MEMORANDUM

DATE: August 19, 2022

SUBJECT: **On-Call Contract #17-067H-1; PO # 8115428**
Traffic Impact Study Reviews
TO #10: Owl Place Commercial Traffic Impact Study Review (CR221)

This memorandum provides a list of comments on the June 2022 Owl & Meridian Commercial Traffic Impact Study (TIS) prepared by SM Rocha, LLC for First Cup. Our comments are based on requirements provided in the County's Engineering Criteria Manual (ECM), Appendix B.

**Figure 2**  
**CONCEPTUAL SITE PLAN**  
 April 2023  
 Page 4

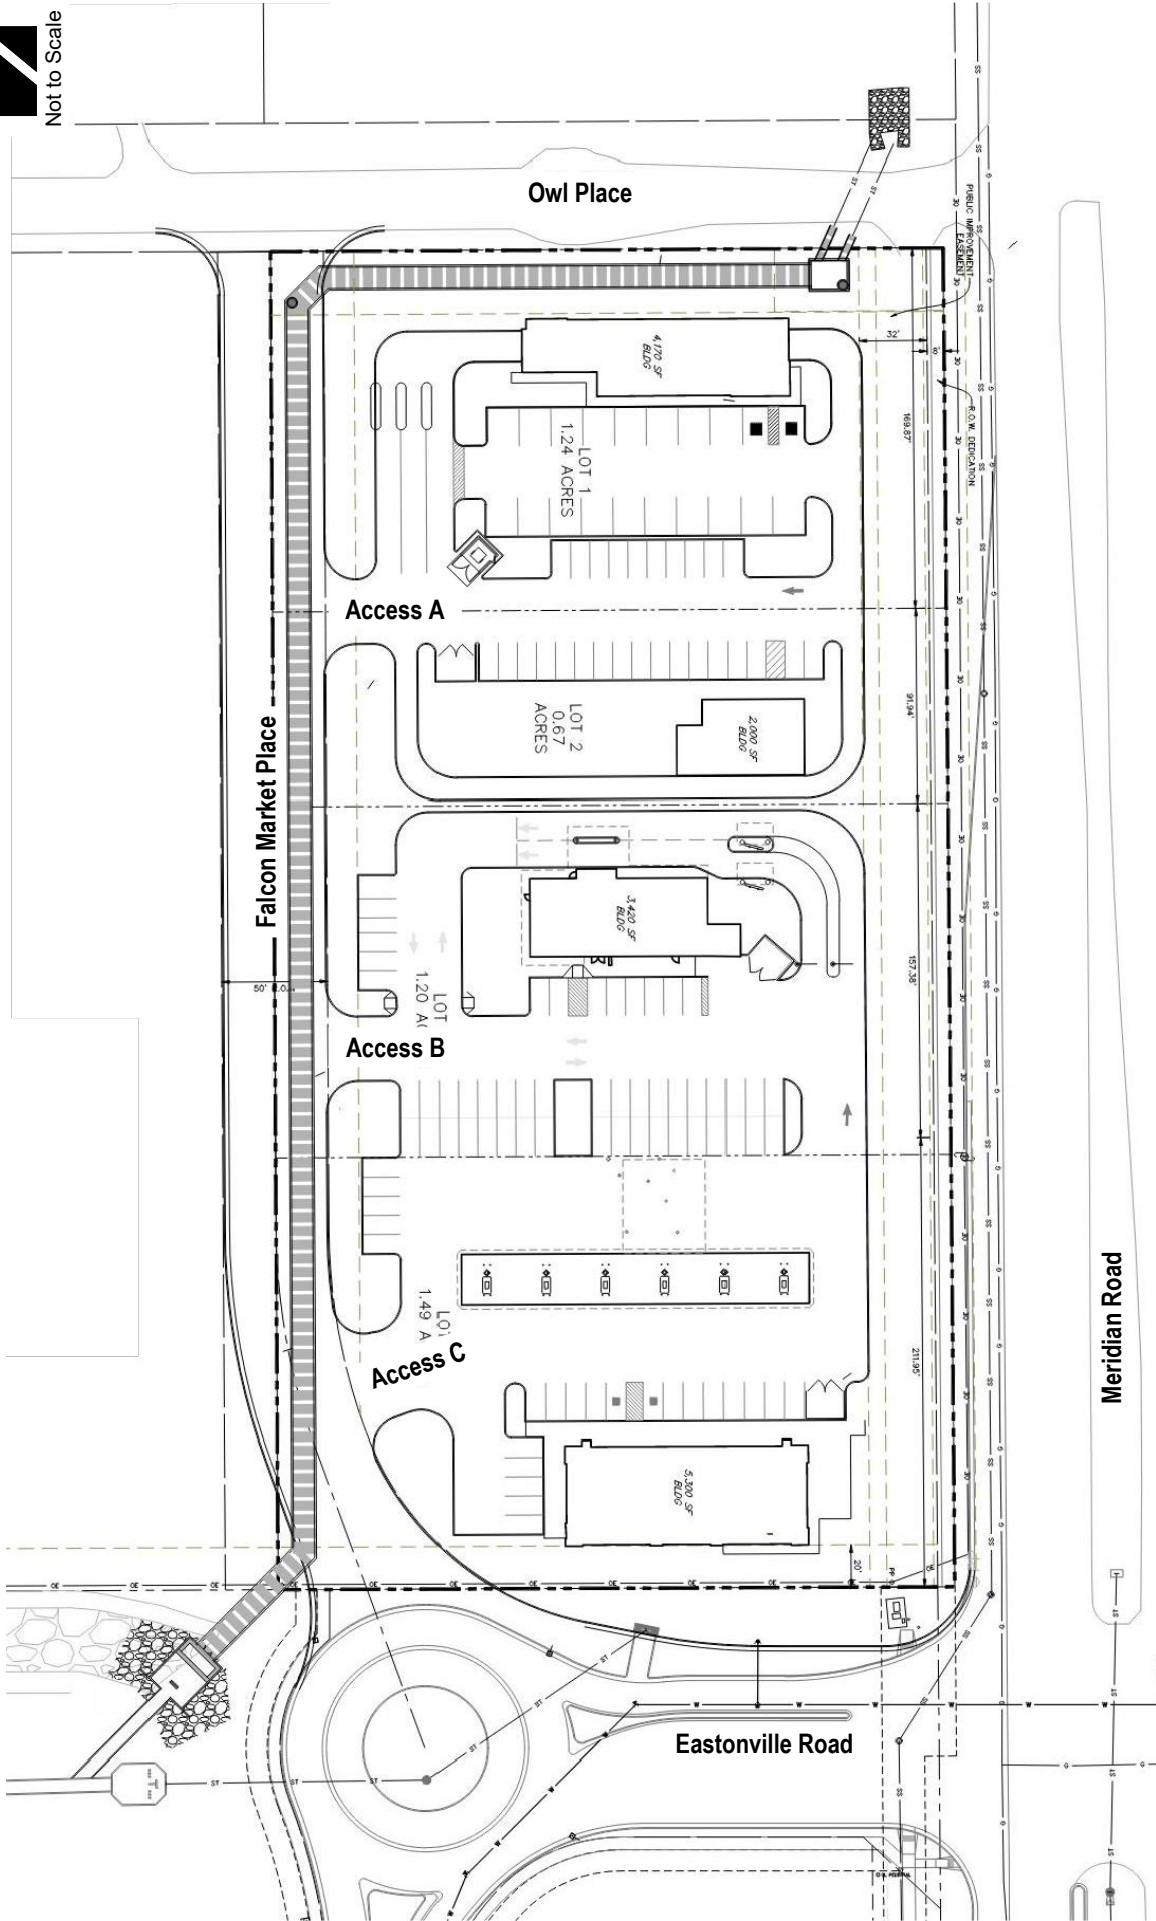
9. Figure 2, the Site Plan, shows five driveways, one for each drive-through establishment, along the access road.
 - a. The northernmost access is very close to Owl Place. An evaluation of access spacing is indicated here.
 - b. These accesses have not been analyzed for traffic volumes, LOS, or queuing. In addition, drive-through queuing within each individual lot has not been evaluated. Potential queuing could impact traffic operations at the access road intersection at Owl Place (Access A) and at the roundabout (Access B).
 - c. The southernmost access is very wide and could create conflicts between inbound and outbound movements.
